Summary of BBOWT's written submissions:

BBOWT strongly opposes the siting and scale of the proposed Rosefield Solar Farm. We recognise the need for renewable energy, but this particular scheme sits within one of southern England's most ecologically valuable landscapes, adjacent to multiple ancient woodlands and within the Bernwood Biodiversity Opportunity Area (BOA). In BBOWT's view, the proposals risk fragmentation of habitats, significant adverse effects on bats and birds with uncertain long term outcomes for biodiversity. Where harm cannot clearly be avoided or convincingly mitigated, we contend that national and local policy dictates the proposal should be refused.

TITLE:
APPENDIX 5A
GREEN AND BLUE INFRASTRUCTURE PARAMETERS
BUFFER WIDTHS - KEY PLAN

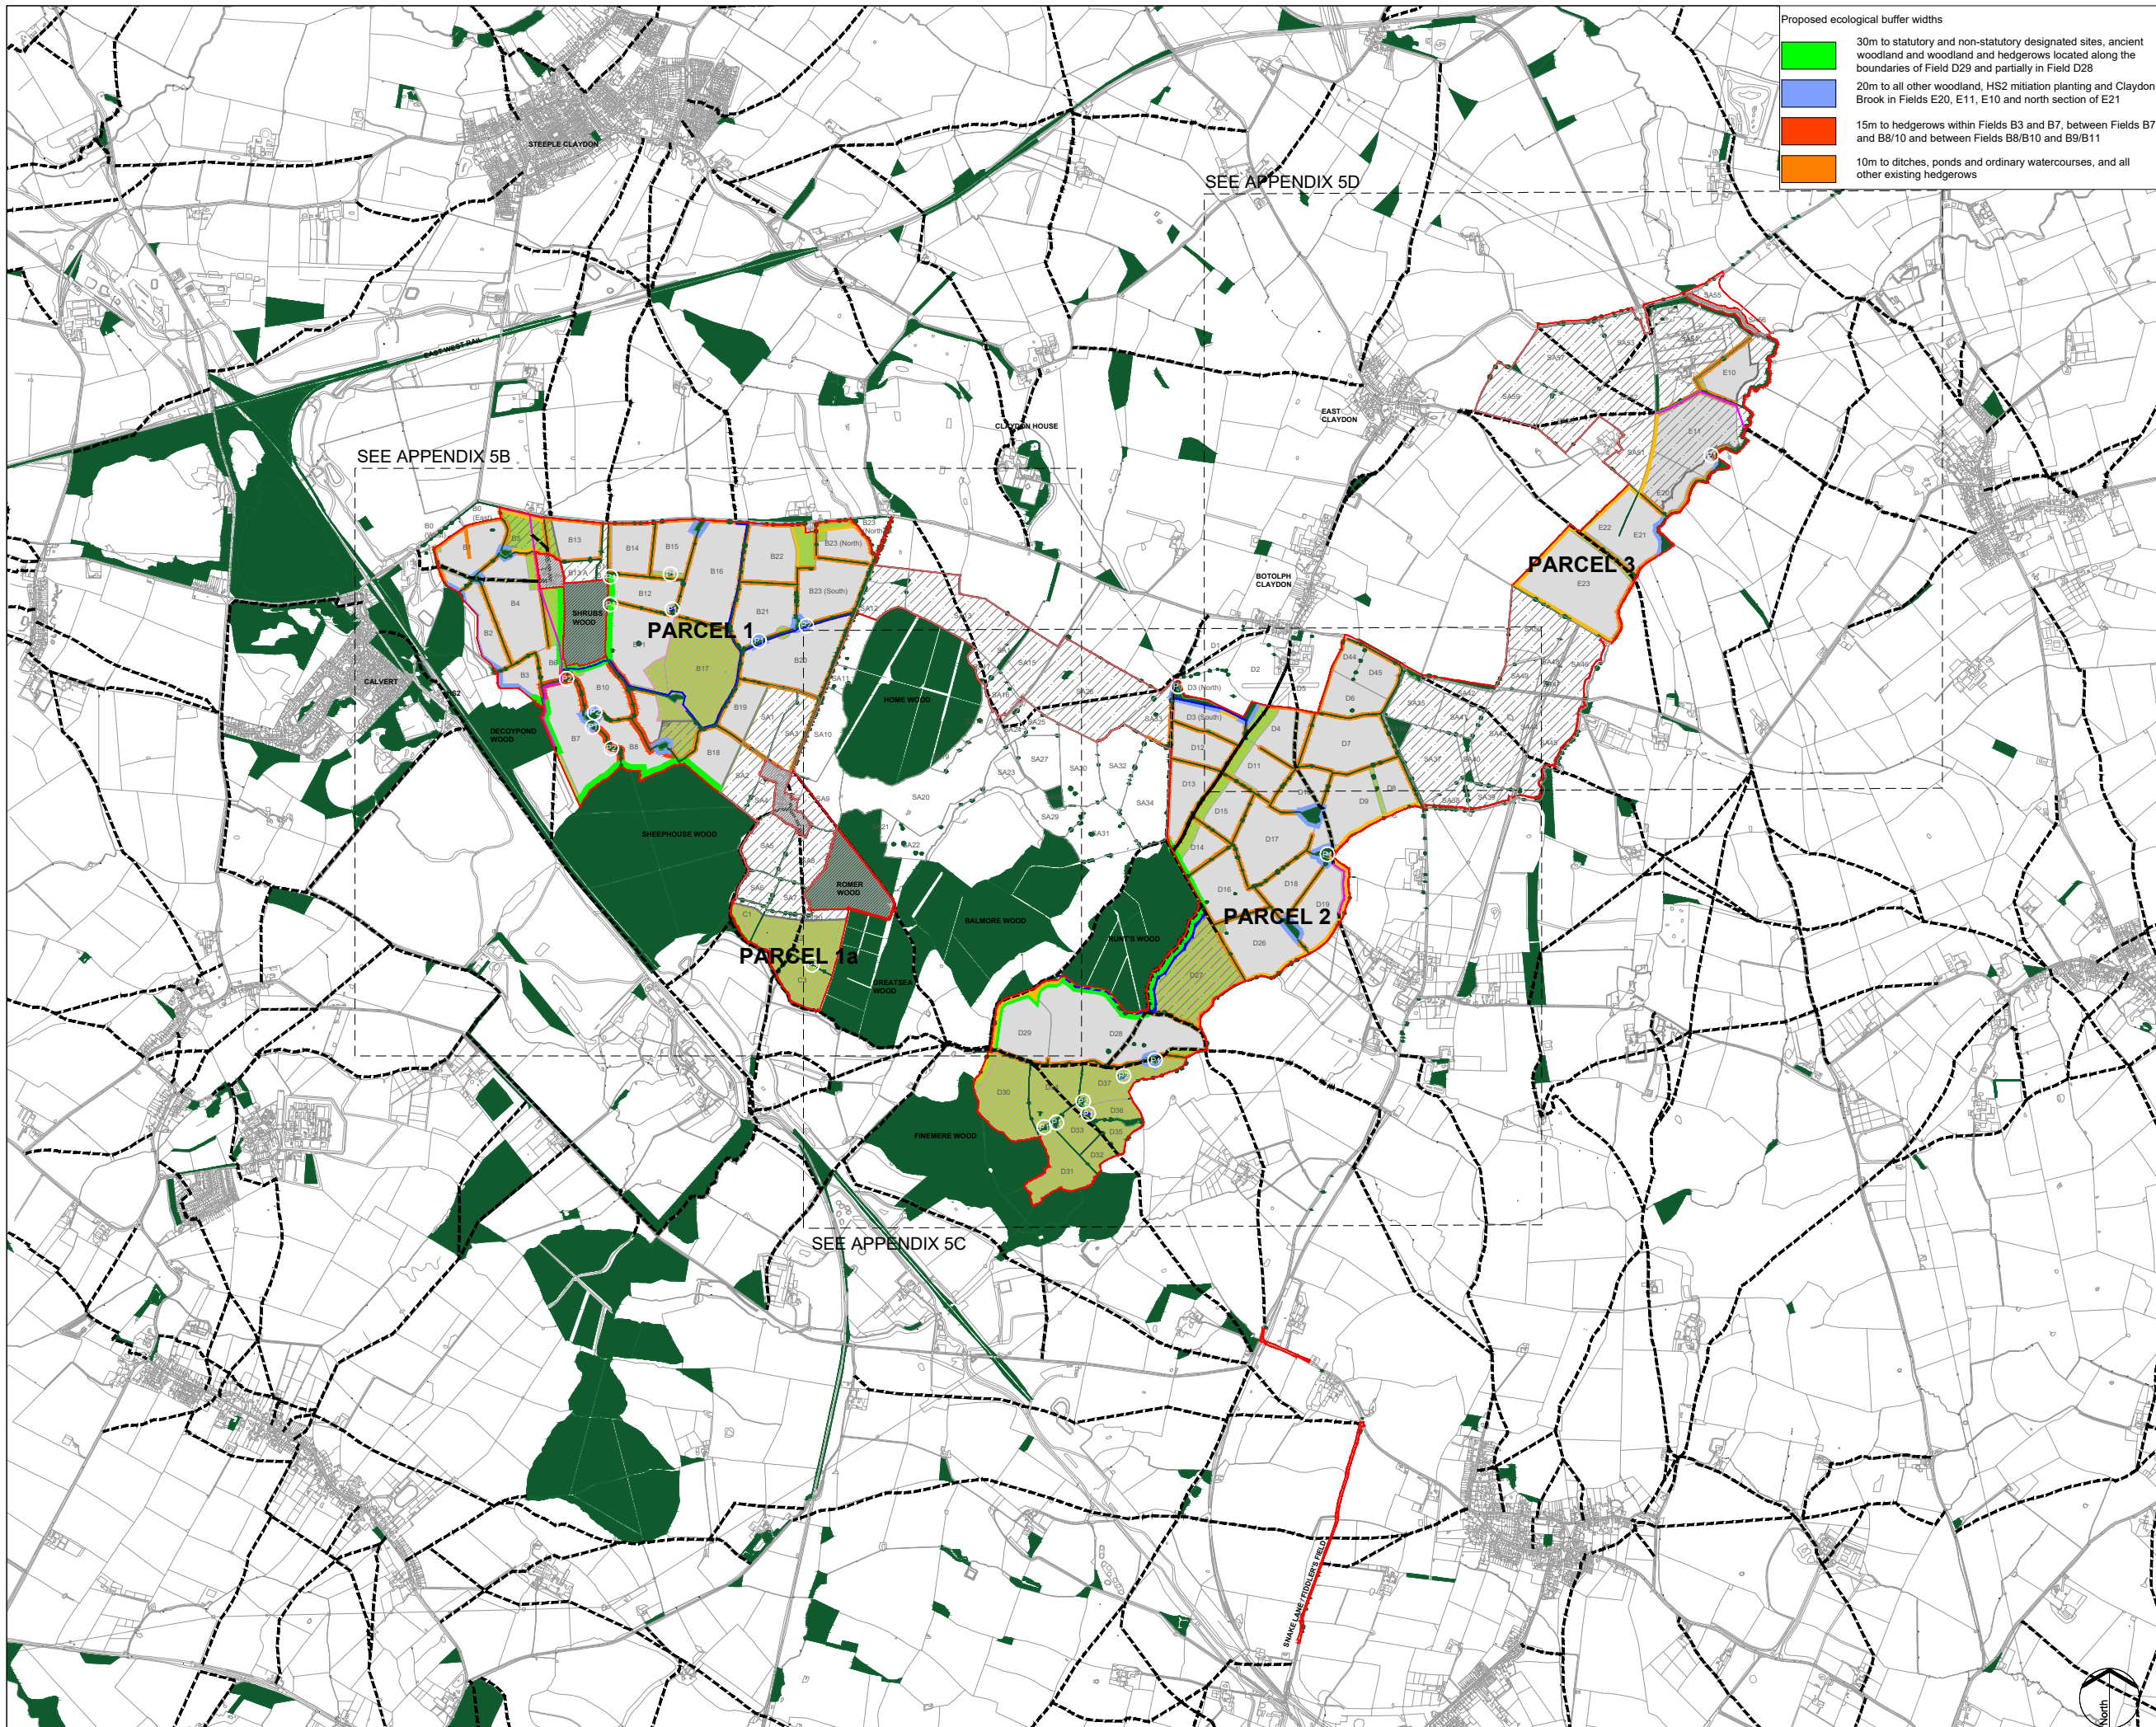
Although the applicant has proposed buffers to designated woodland, the minimum 30 metre offset is inadequate. We seek a minimum 50 metre buffer, and potentially more where disturbance could be significant, to protect woodland function, edge habitats, and dependent species.
